Consultation Response from: KC Environmental Health (Pollution & Noise Control)
2026/91564, land off, Heaton Grange, Hanging Heaton, Batley, WF17 6EN
Erection of 21 dwellings
Date Responded:
09/09/2026
Responding Officer:
CH / MN
Responding Ref:
WK/202627309

Environmental Health was previously consulted on the proposed development of 21 dwellings at land at Hanging Heaton, with comments provided on 4 August 2026. An updated Noise Impact Assessment by Apex (Ref. 11457.2 Rev C, dated 5 March 2026) has since been submitted for review. This response is limited to consideration of the revised Noise Impact Assessment, as all other Environmental Health matters were addressed in our previous consultation response.

Figure 1: Key of the proposed minimum façade sound insulation treatment (mark-ups detail as per Table 1) and acoustic barrier location (green line)

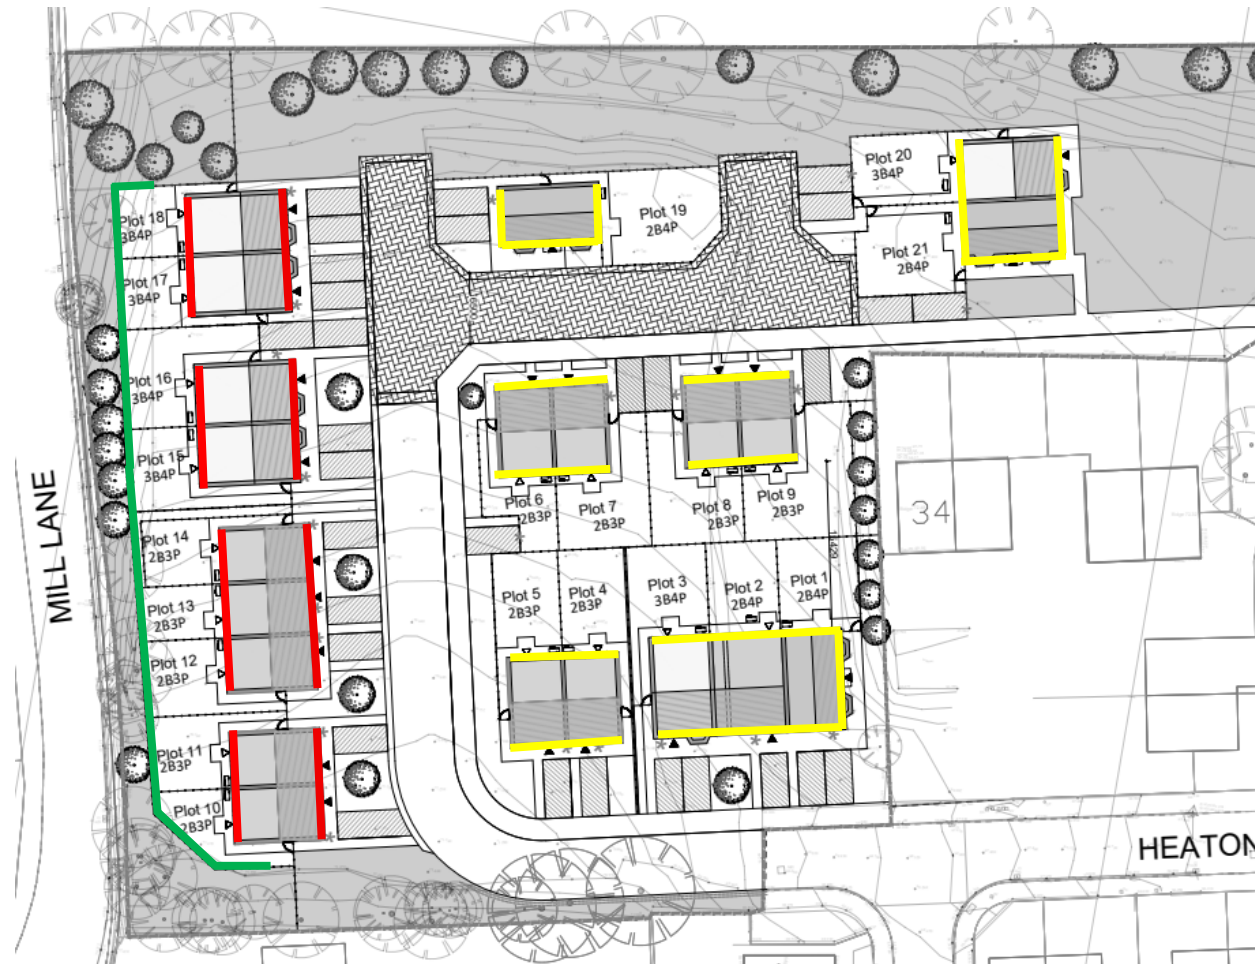
In order to meet with the external requirements of BS8233, a 2.4m high acoustic barrier is proposed to plots 10 to 18 and a minimum specification is given in para 6.4. In order to meet with the internal requirements of BS8233, glazing and ventilation is recommended in table 1 and this is reflected in a colour coded format in figure 1, as is the acoustic barrier.

The submitted information is accepted. A condition is recommended to secure the mitigation measures in the interests of protecting the amenity of future occupiers.

NC1 Implement Agreed Noise Mitigation Measures – Condition

Before the development is first brought into use, all works which form part of the sound attenuation scheme as specified in the Noise Impact Assessment authored by Apex dated 05 March 2026 Ref 11457.2 RevC:

- a) shall be completed; and
- b) written evidence to demonstrate that the specified noise levels have been achieved shall be submitted to and approved in writing by the Local Planning Authority.
